Appeal Decision

Appeal Ref: APP/R5510/W/23/3334251

Land adjacent 1 Clovelly Avenue, Ickenham, Hillingdon UB10 8PR

- The appeal is made under section 78 of the Town and Country Planning Act 1990 against a refusal to grant planning permission.
- The appeal is made by Mr Abdul Hakim Dadajan against the decision of the Council of the London Borough of Hillingdon.
- The application Ref 50334/APP/2023/946, dated 30 March 2023, was refused by notice dated 31 May 2023.
- The development proposed is the erection of a new detached dwelling with car parking space and private amenity.

1 Site Plan Proposed  
1 : 500

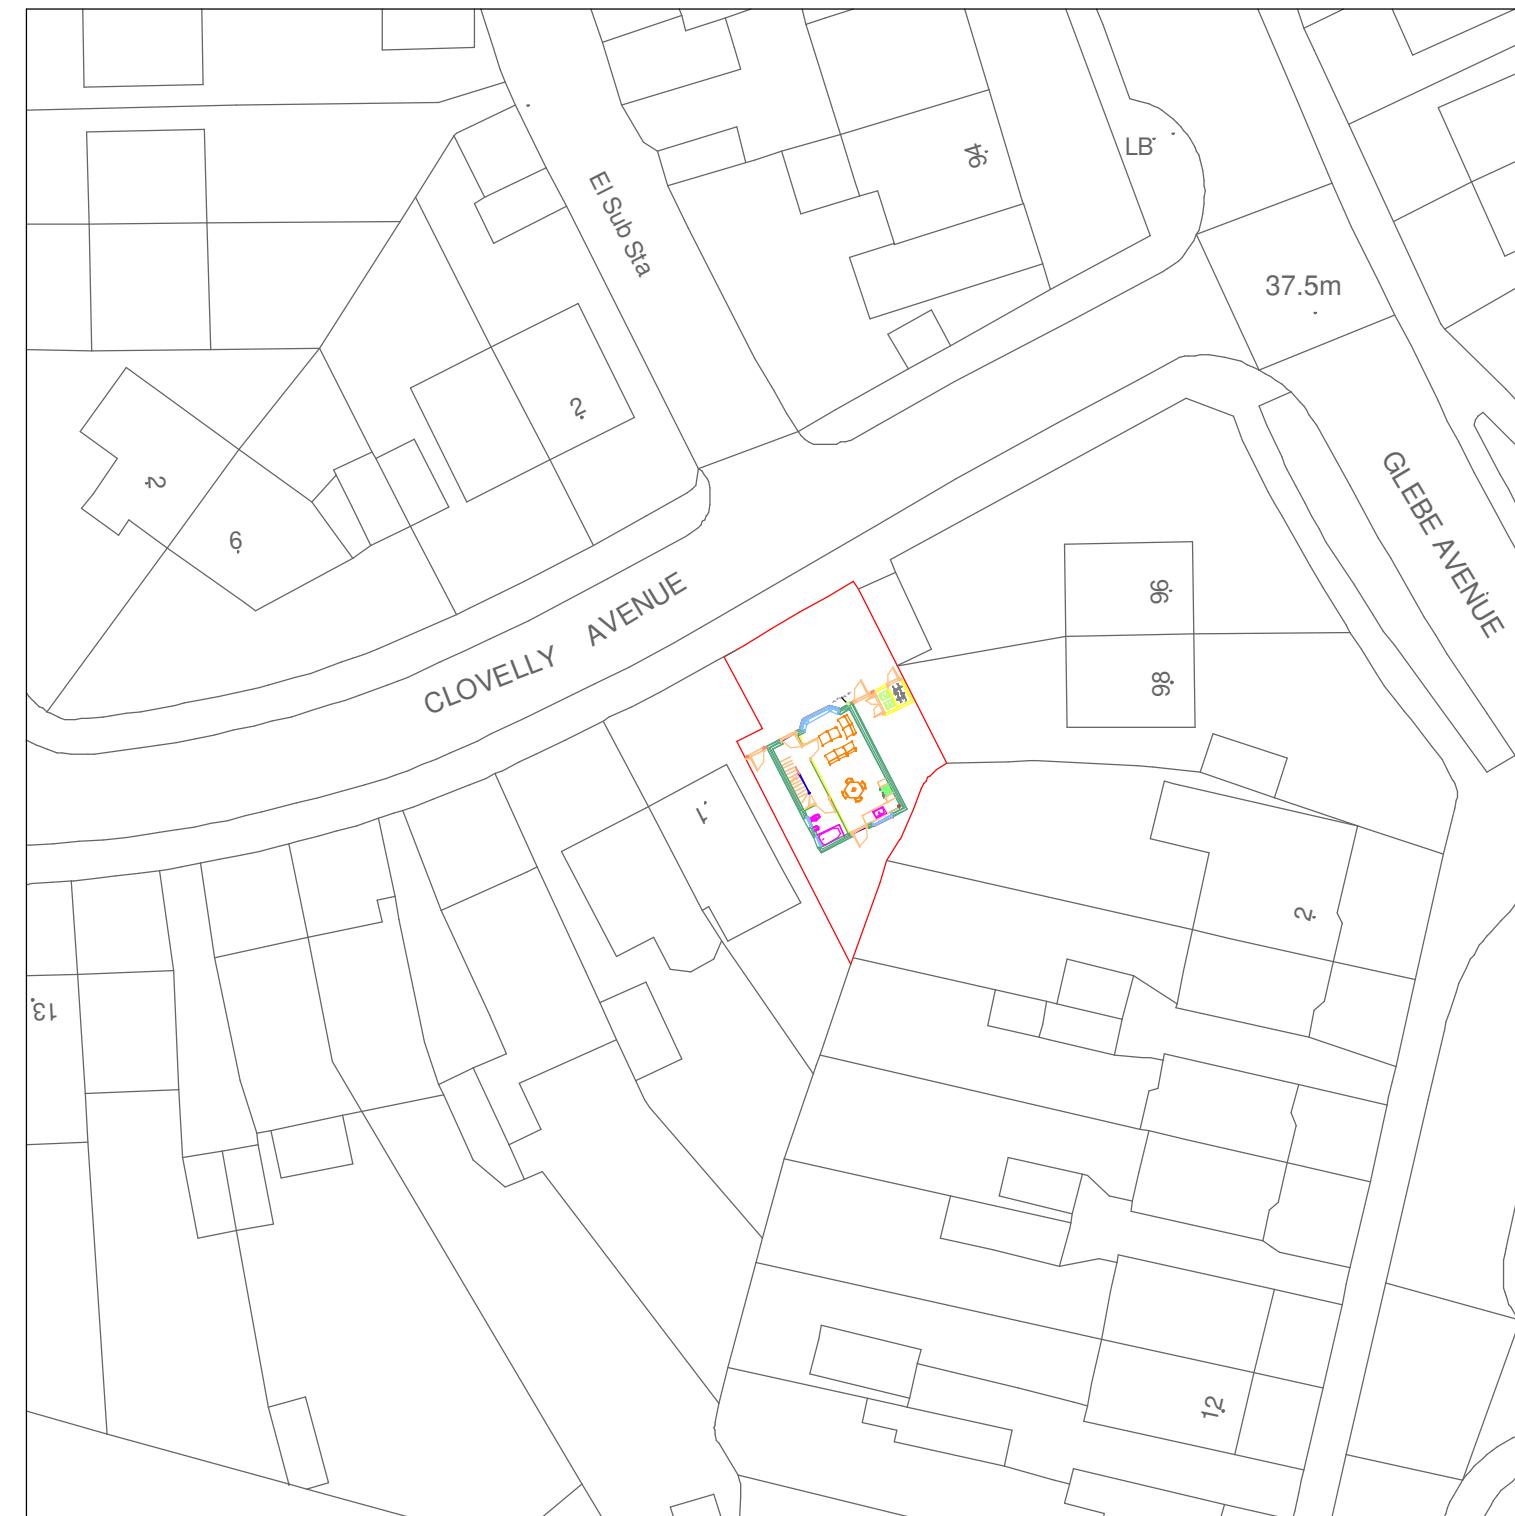
4. The proposed dwelling would be set back from Clovelly Avenue and there would be no habitable room windows in its side walls. However, its rear face would include a door and kitchen window at ground floor and bedroom windows in the floor above. Given the plot's dimensions and its tapering shape, those openings, particularly towards the eastern corner of the building, would be very close to the rear boundary shared with 2 and 4 Burnham Avenue. The Council calculates that, at its closest point, the distance from the proposed building to that boundary would be just 0.5 metre.

5. As a result, there would be direct overlooking at very close quarters from the upper floor habitable room windows in the rear face of the proposed dwelling to the end of those two properties' rear gardens, and a general loss of privacy within them. Additionally, given the proposed dwelling's two storey form and its siting relative to that boundary, it would loom over those gardens, causing a significant overbearing impact.
